Accessibility Report

20-22 Atchison St
St Leonards, NSW

Report No: 25056-201-R01 Access Report
Revision: 02
Date: 22 September 2025

- a) Architectural SSDA issue drawings Rev 1 dated 18/09/2025 prepared by Cox Architecture (Project No. 223107.00)

Co-ordinated: KH	Drawn: KH
Project Architect: RB	Scale: 1 : 50 @ A1
Project Director: RJ	Date: 18/09/2025
Drawing Number: A-DA-8107	Revision: 1

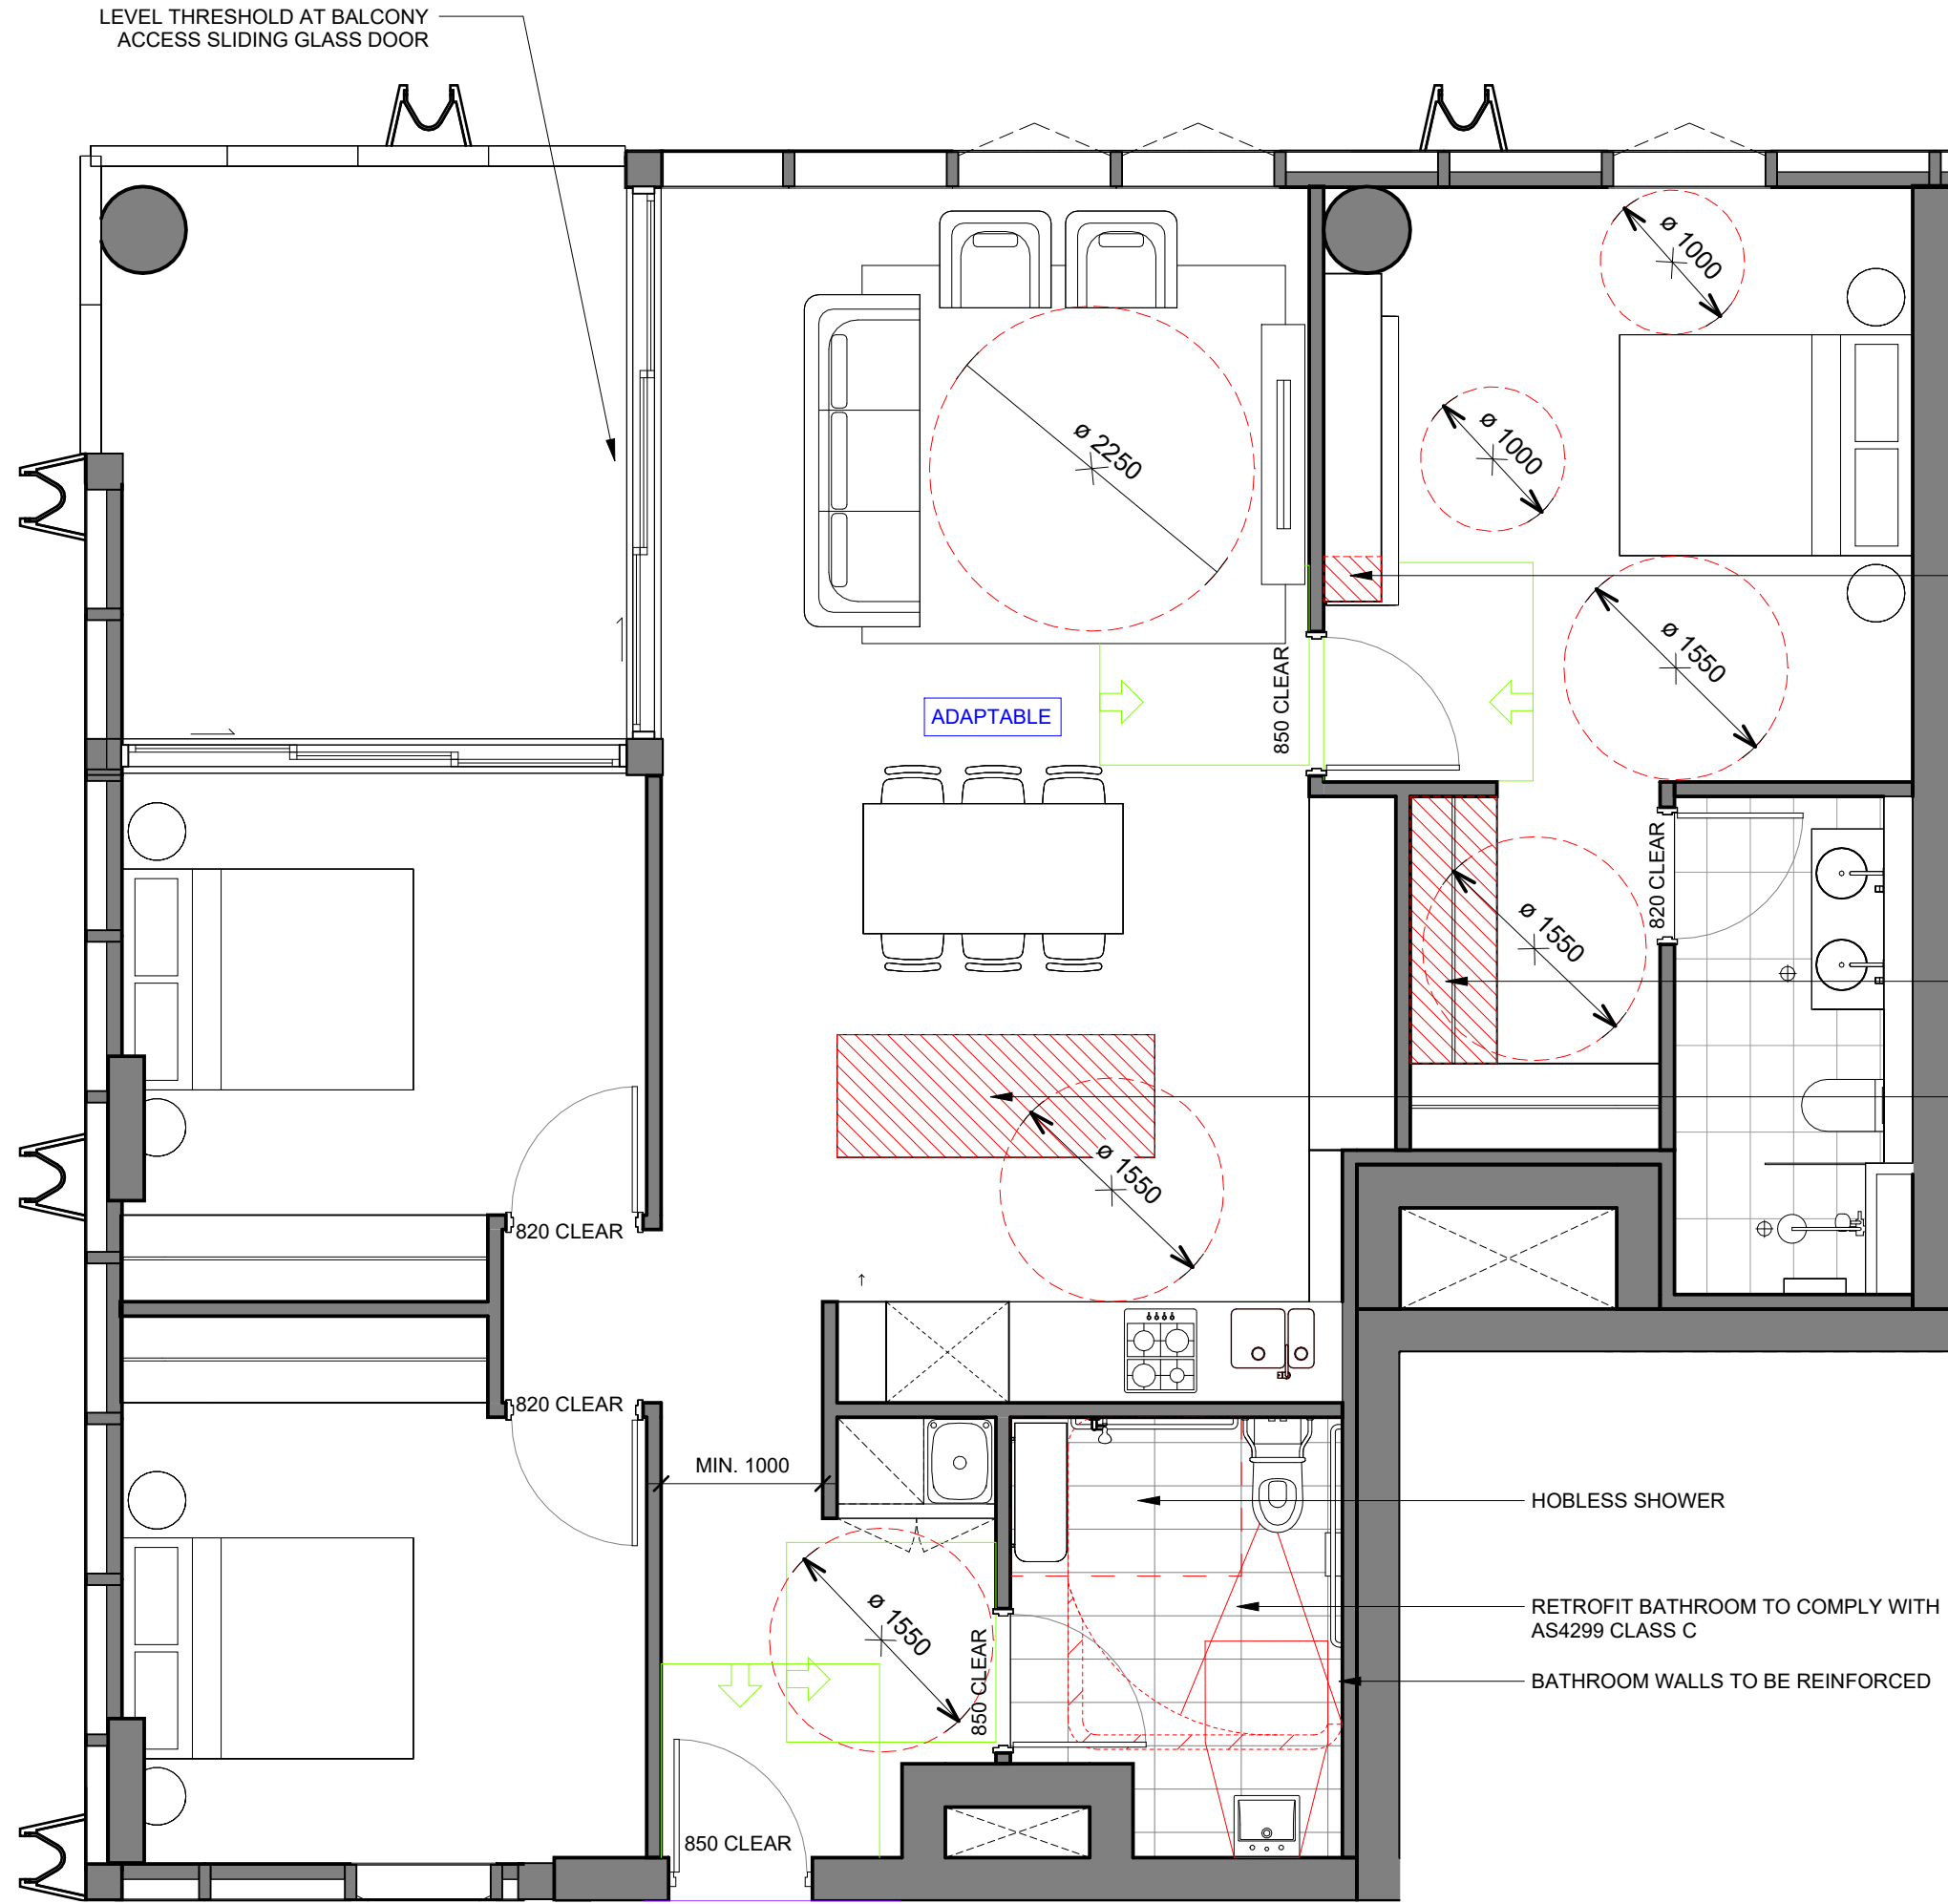
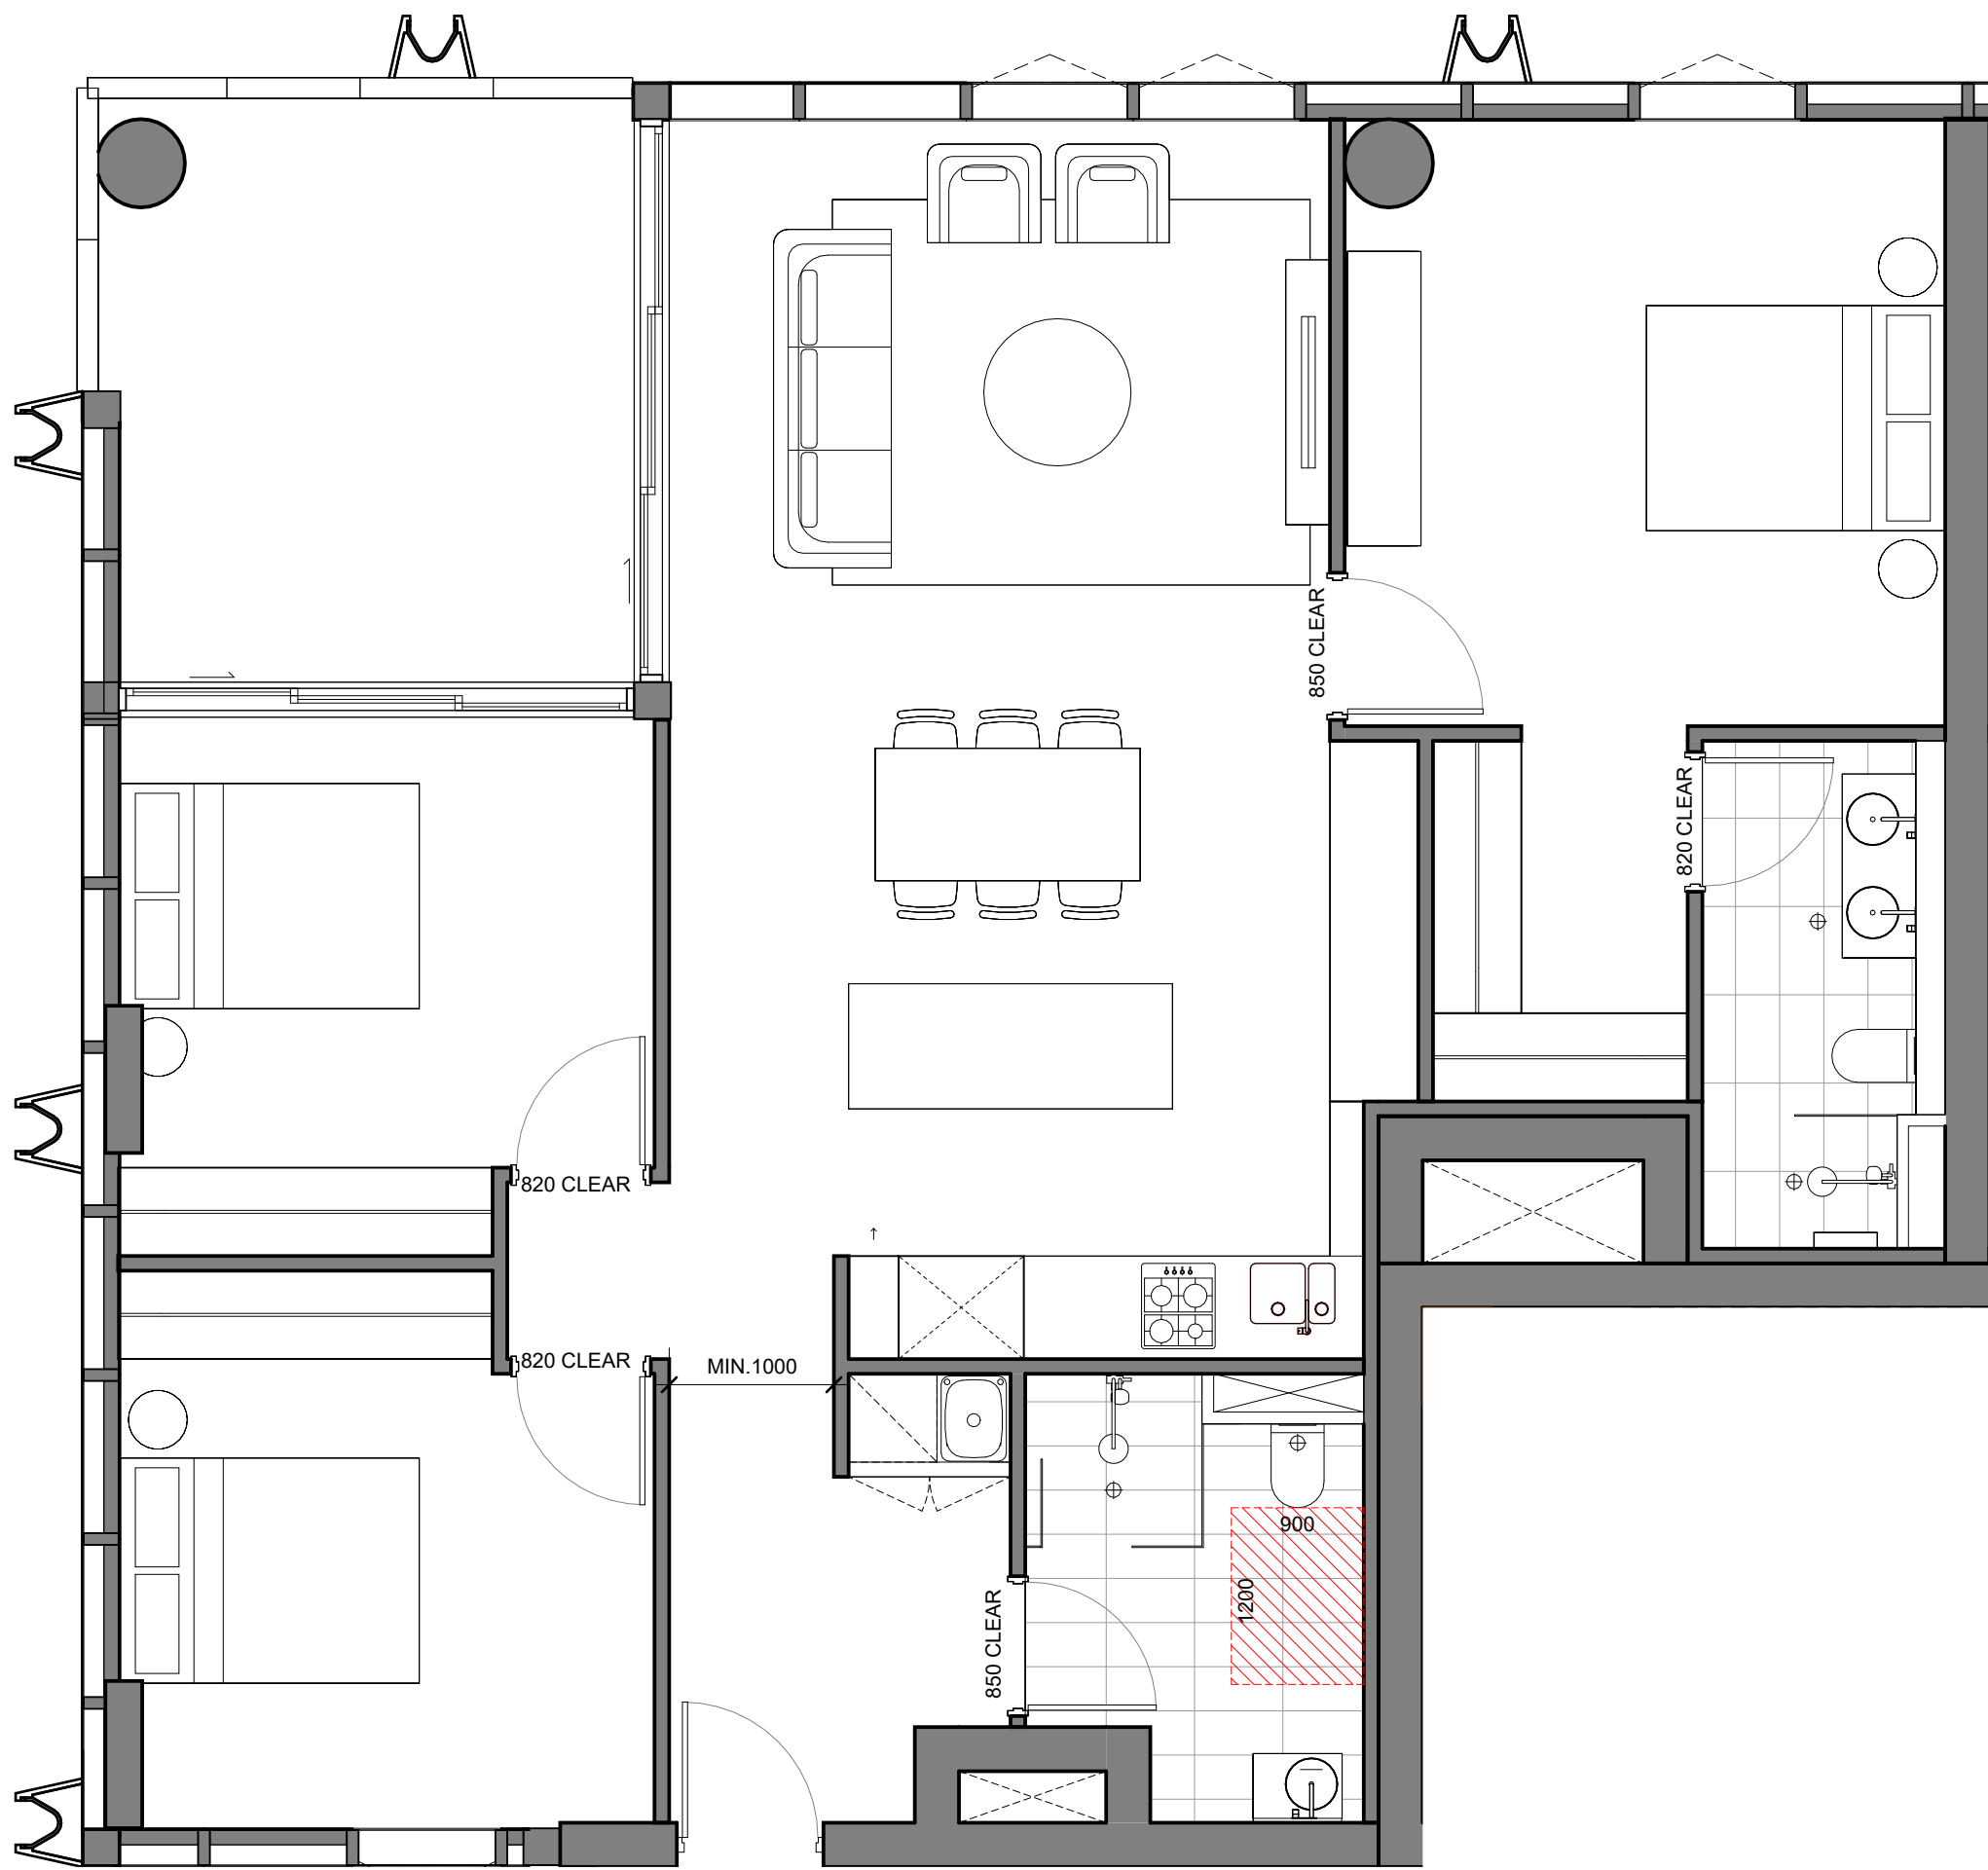
Refer marked plans for areas requiring review.
